Application No: AW/344/14/HH

Recommendation Report for Planning Permission for Works or Extension to a Dwelling

LOCATION: 68 The Drive
Bognor Regis

Drq No.	Rev
68/2014/60P	A

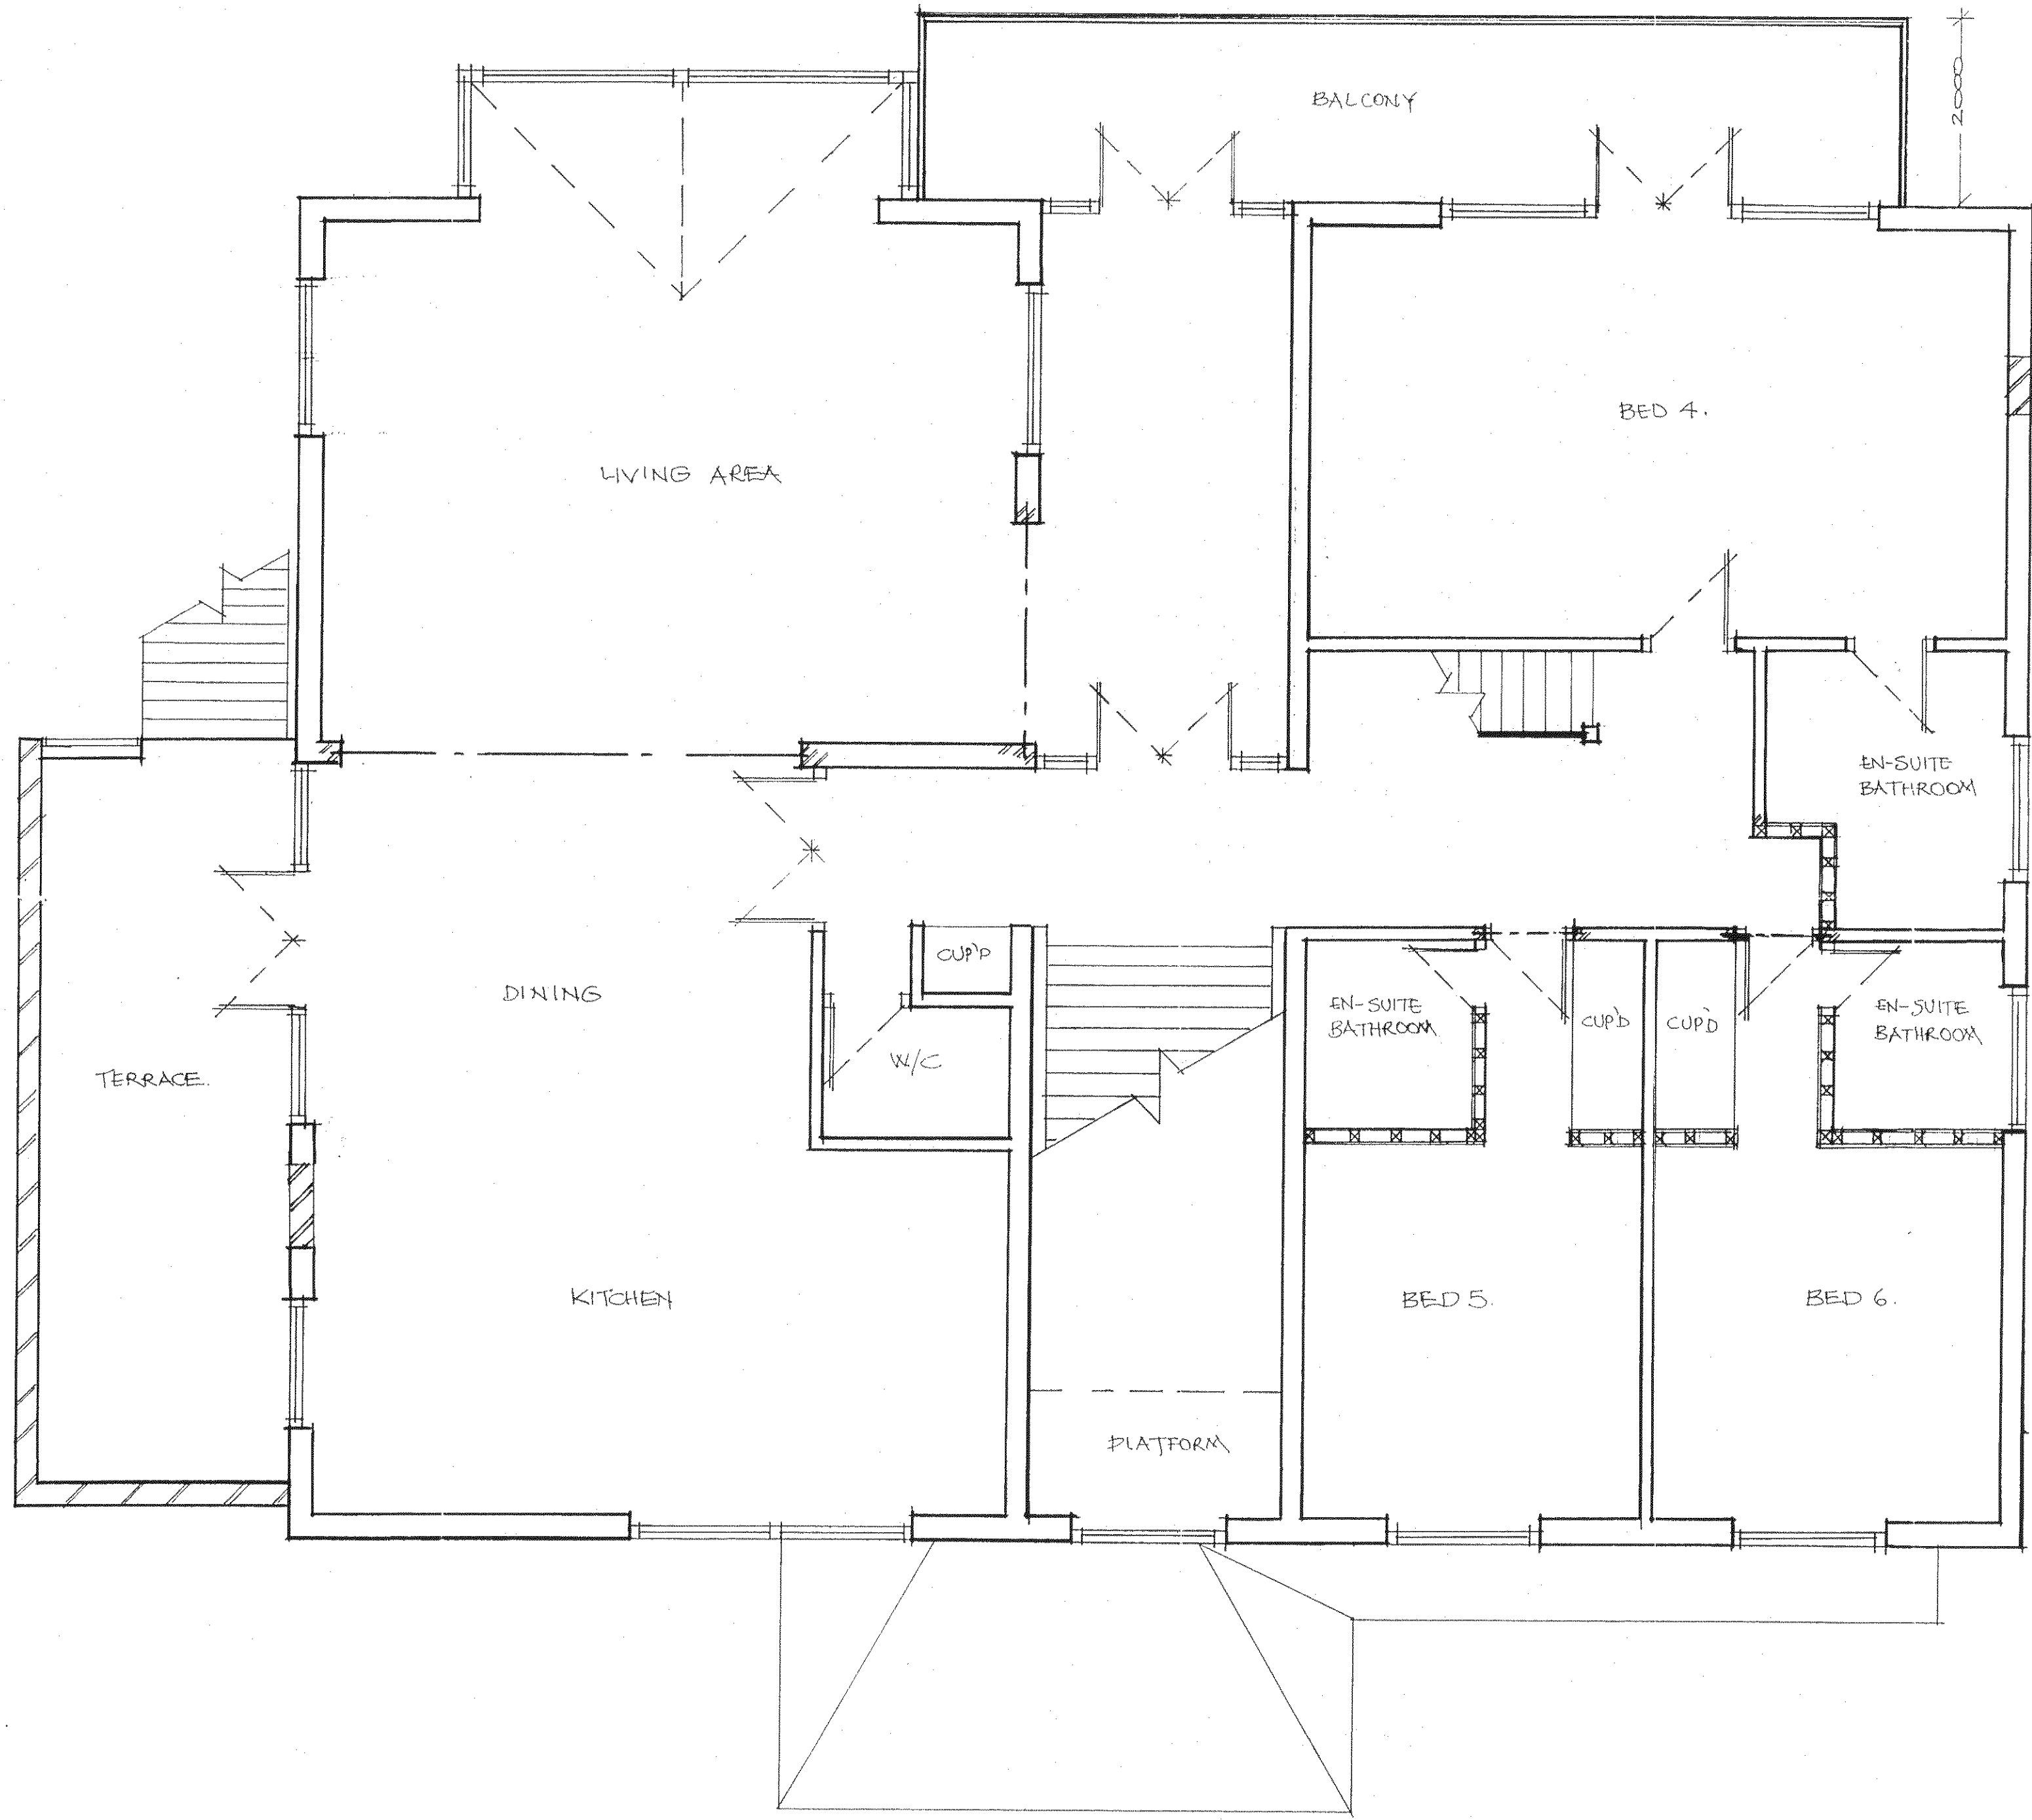
The proposed alterations to the eastern elevation of the property will see an increase in size of the existing balcony and potentially give rise to additional overlooking of the adjoining property at 70 The Drive. It is also felt that the proposed alterations to the rear balcony have the potential to create additional overlooking of the property at 66 The Drive. However, this overlooking could be prevented through the use of planning conditions requiring the installation of obscured screening.

- 5 No development shall be carried out unless and until details of obscured screening up to 1.8 metres in height have been submitted for the eastern wall of the balcony on the eastern elevation and the western edge of the rear balcony have been submitted to and approved by the Local Authority. The screening hereby approved shall be constructed within 1 month of the completion of this development and thereafter permanently retained.
